Addendum No. 1

RE: Contract ID: C201293

Hoke County (B-4152)

Bridge over Puppy Creek and
Approaches on SR-1422.

UTILITIES BY OTHERS

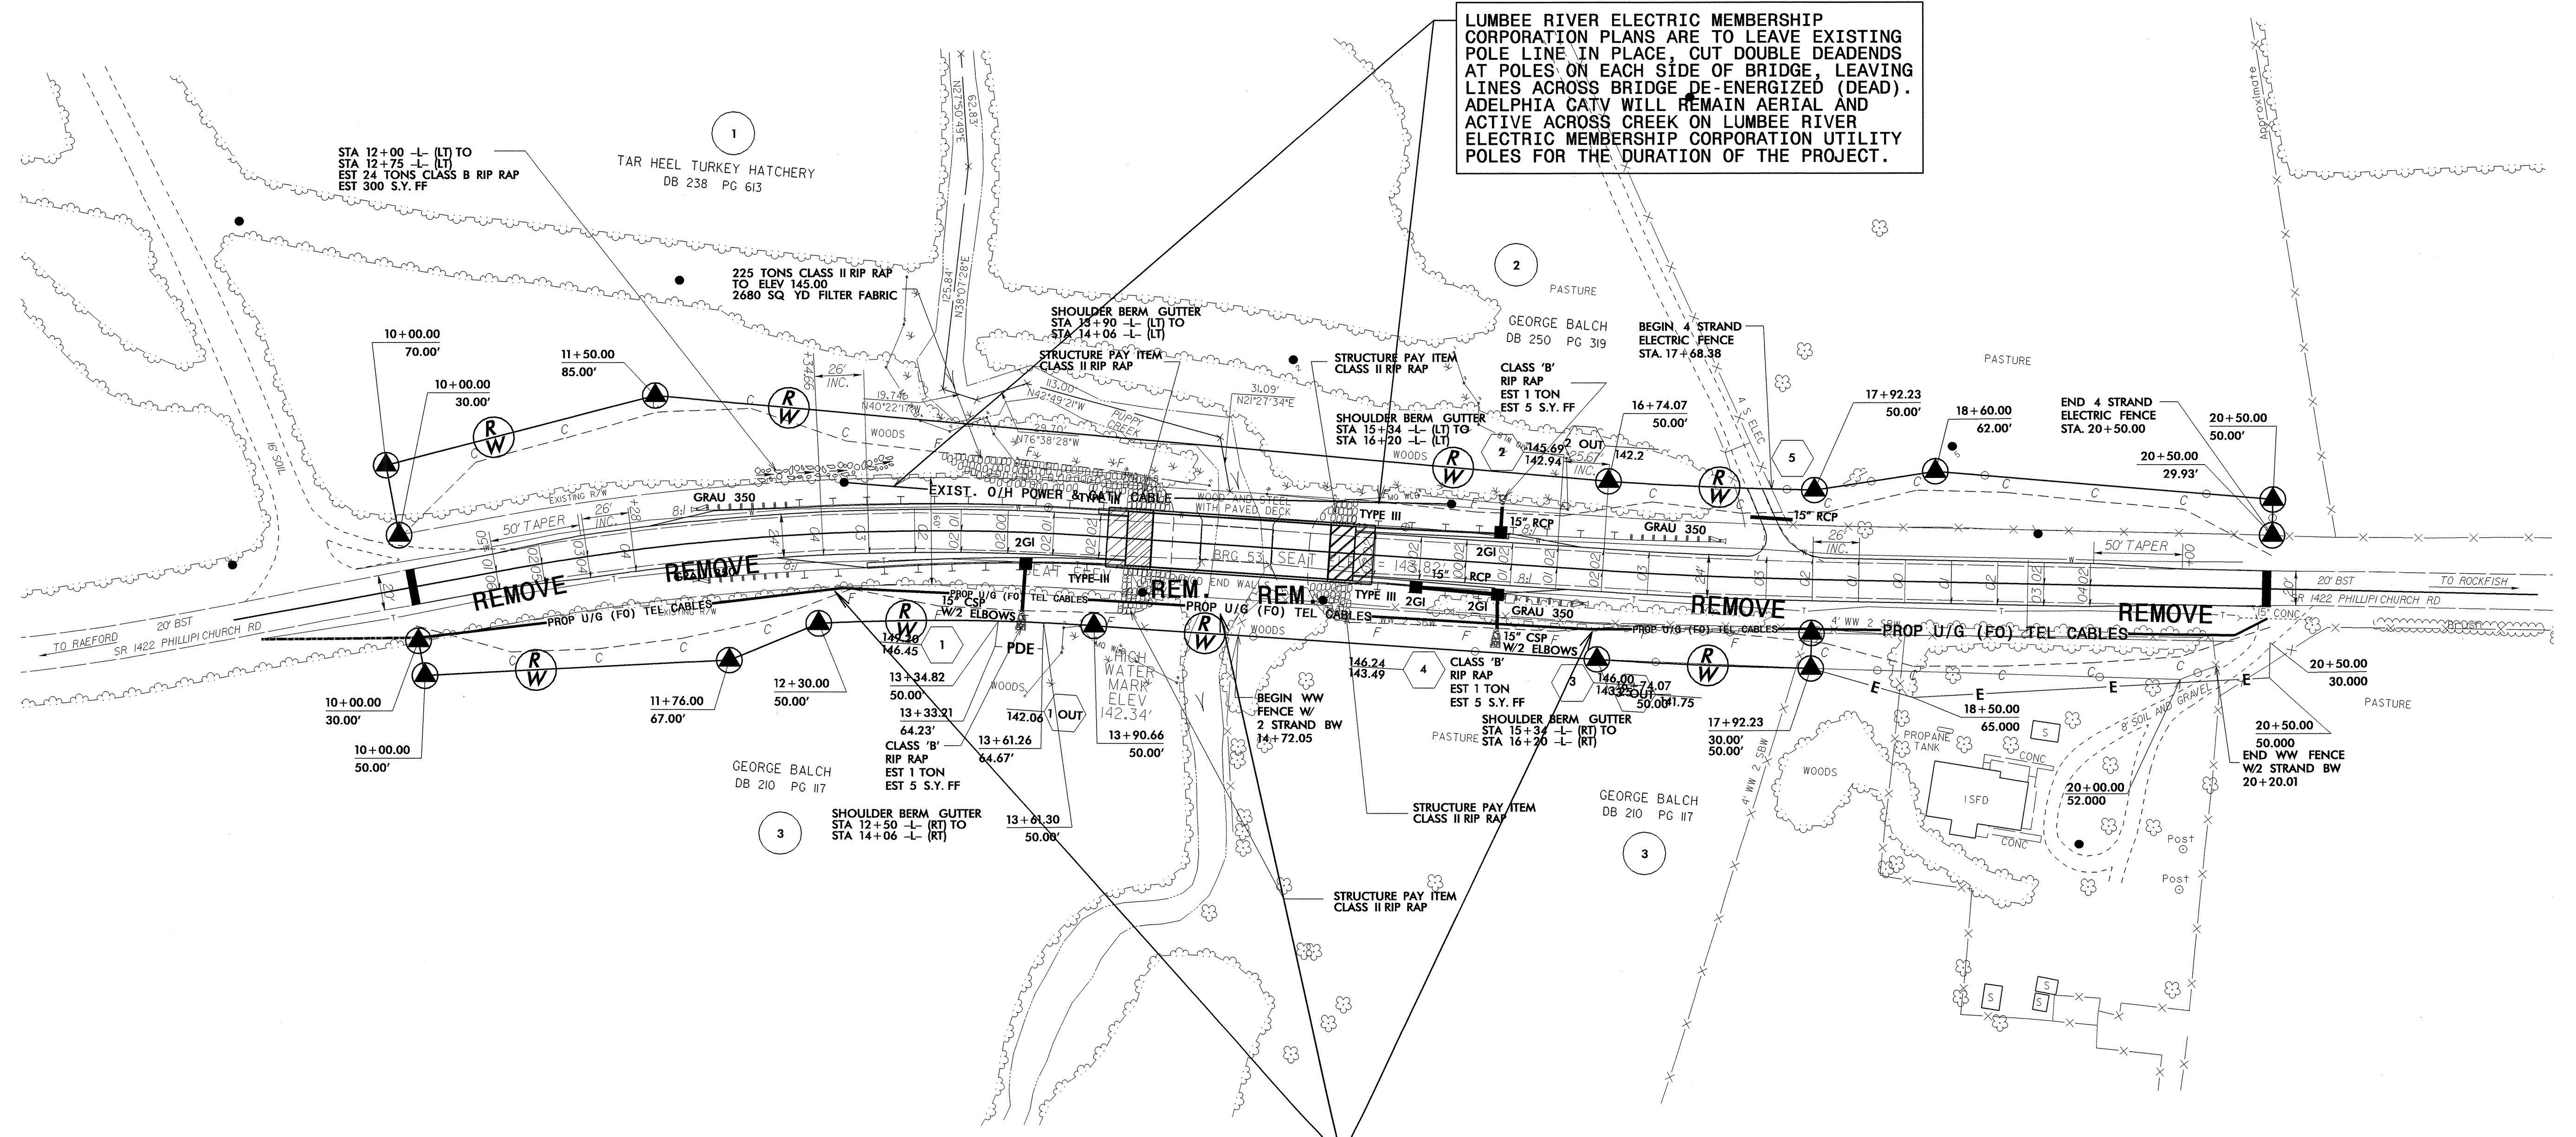
On Page No. 72, paragraphs "A" and "B" of the project special provision entitled "Utilities By Others" has been revised to show dates for utility relocations.

- A. SPRINT TELEPHONE
The new telephone/fiber optic cables will be directionally bored the entire length of the project and to a depth of fifteen (15) feet below creek bottom. The existing utility poles and line will be removed by April 17, 2006. See Utilities by Others Plans for details.

- B. LUMBEE RIVER ELECTRIC MEMBERSHIP CORPORATION
The existing lines on the north side of bridge will be dead-ended and de-energized by date of availability. The lines will remain on the utility poles during construction. One existing utility pole located at -L- line station 19+18.36, 28.03 ft. left of centerline shall be relocated outside the cut area adjacent to the proposed right-of-way by June 16, 2006. All other existing utility poles will remain in place and be reused after the bridge project is complete. See Utilities by Others Plans for details.

- C. ADELPHIA CATV
The existing lines will be remain aerial and active on Lumbee River EMC utility poles for the duration of the project construction. See Utilities by Others Plans for details.
